From: Anita Gardner <Anita.Gardner@arun.gov.uk>
Sent: 16 August 2021 10:10
To: Planning.Responses <Planning.Responses@arun.gov.uk>
Subject: FW: F/7/21/PL

Subject: RE: F/7/21/PL

Thanks for your comments on this application are responses are as follows:

I'm just checking that you're not waiting for anything else from me or the client re: F/7/21/PL – 1.28 Ha High-Tech Glasshouse & Reservoir.
Don't hesitate to let me know if you need anything else.

Drawing Title
Proposed Lagoon

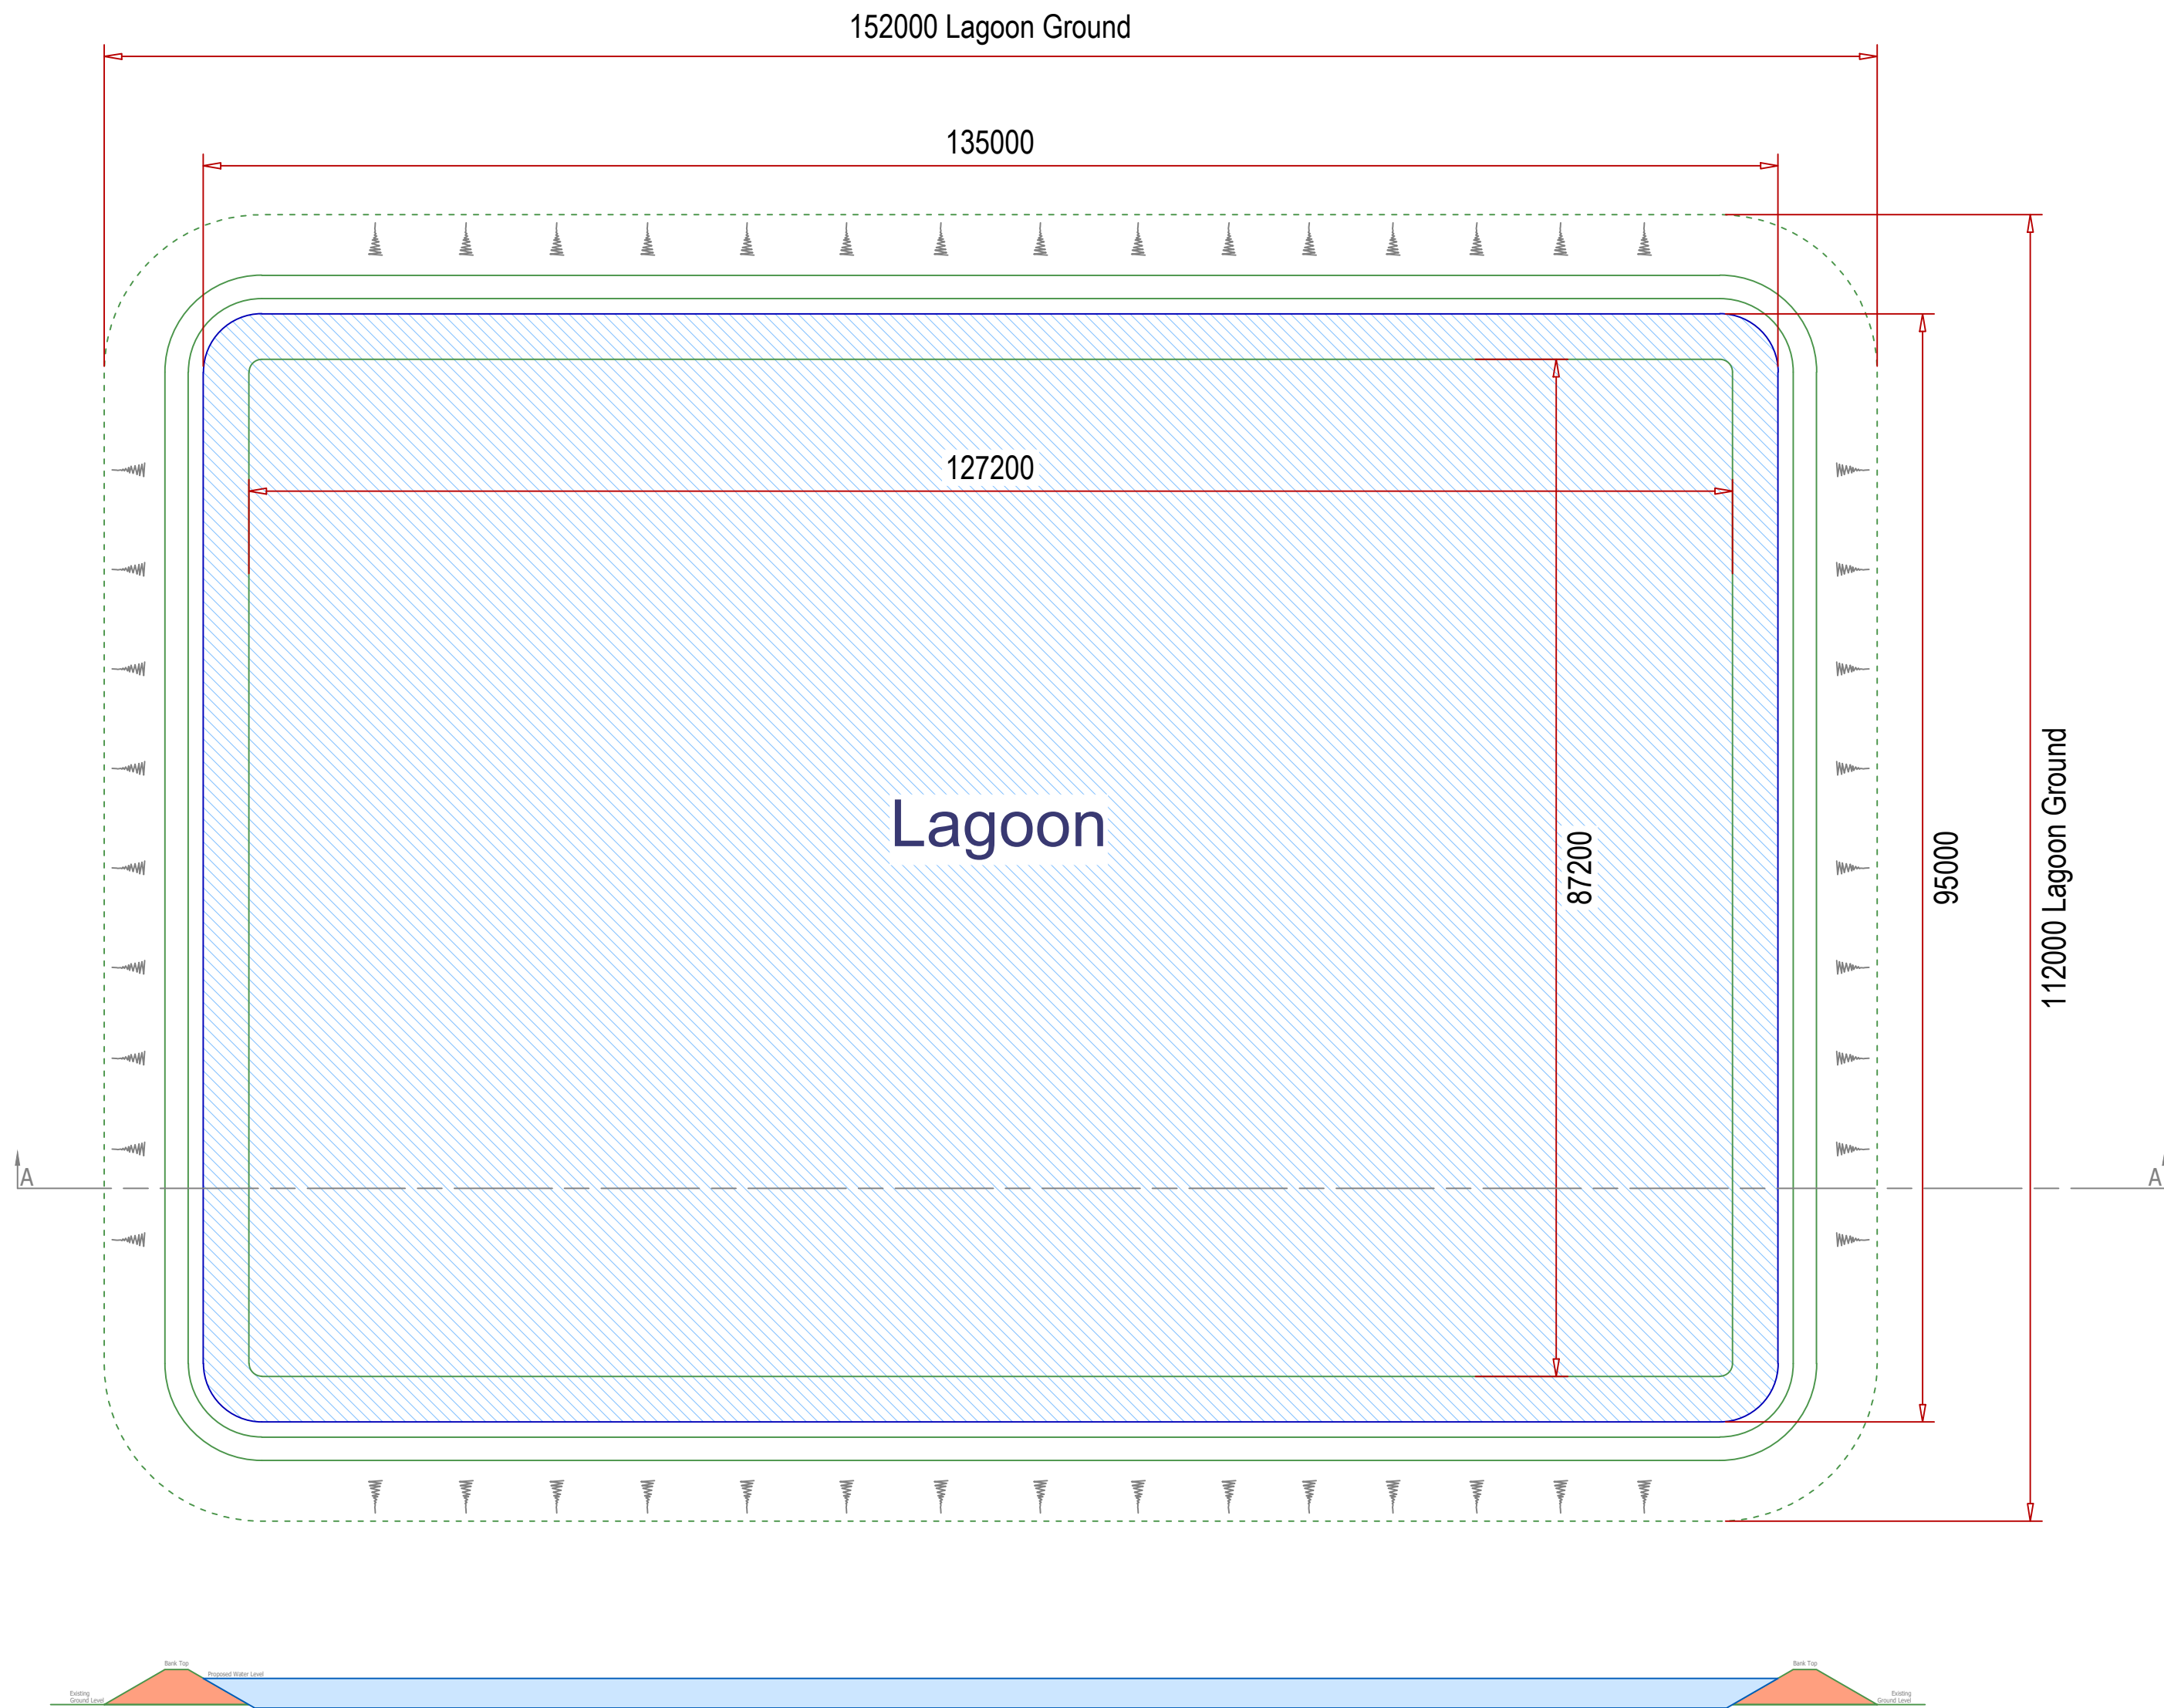
- There is no indication of the capacity of the reservoir in the submitted Flood Risk Assessment (FRA). Our initial calculations suggest that this would be classed as a Large Raised Reservoir. Subsequently, we would require further details of how this proposal would be planned, designed and constructed in accordance with the Reservoir Act requirements. This includes appointing an All Reservoir Panel Engineer as a construction engineer to oversee and supervise building the reservoir.

We have updated the details of the reservoir to clarify the proposals. We confirm the maximum retained water volume is less than the 25,000m³ which would be considered a Large Raised Reservoir. After a 100 years storm event +40% CC the Reservoir could holding a maximum of 22,970m³, the maximum retained water within the Reservoir for irrigation is 19,500m³. We attach an updated plan detailing the Reservoir dimensions. Based on the above an All Reservoir Panel Engineer as a construction engineer to oversee and supervise building the reservoir will not be required.

RESERVOIR SECTION
(Scale 1:100)

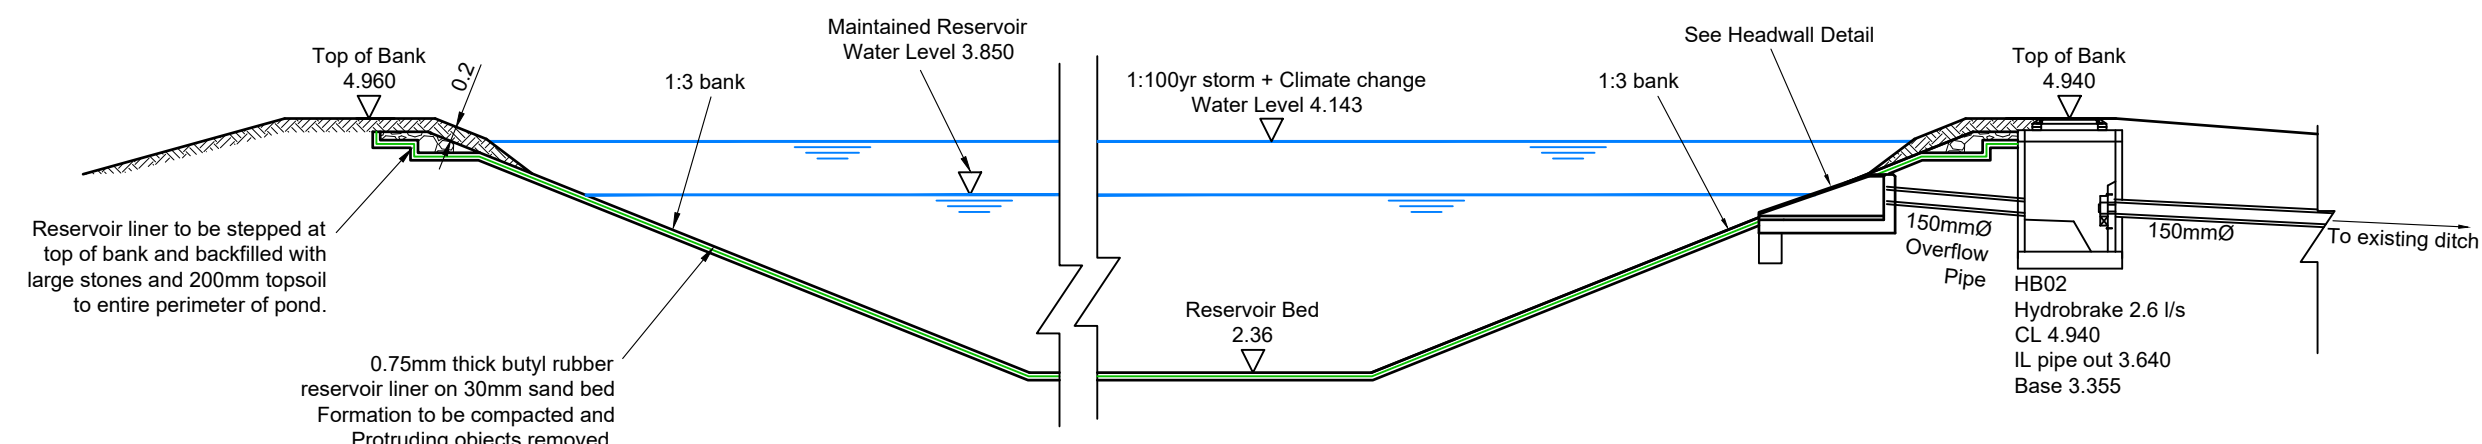
- The reservoir should be constructed in accordance with the Small embanked reservoirs CIRIA Guidance 161 (side slopes 1 in 3 and a crest width of 3 metres) and there should also be details of the overflow arrangement.

Proposed Reservoir dimensions and arrangement has been updated to include 1 in 3 banks and a crest width of 3m in accordance with Small embanked reservoirs CIRIA Guidance 161. The northern bank will be constructed with banks 300m lower than the eastern, western and southern banks to provide an over flow route towards the River and away from any buildings and development. It should also be noted that a 300mm free board allowance has been provided above the 1 in 100 year +40% cc storm level, providing over double the storage required above the retained water level.
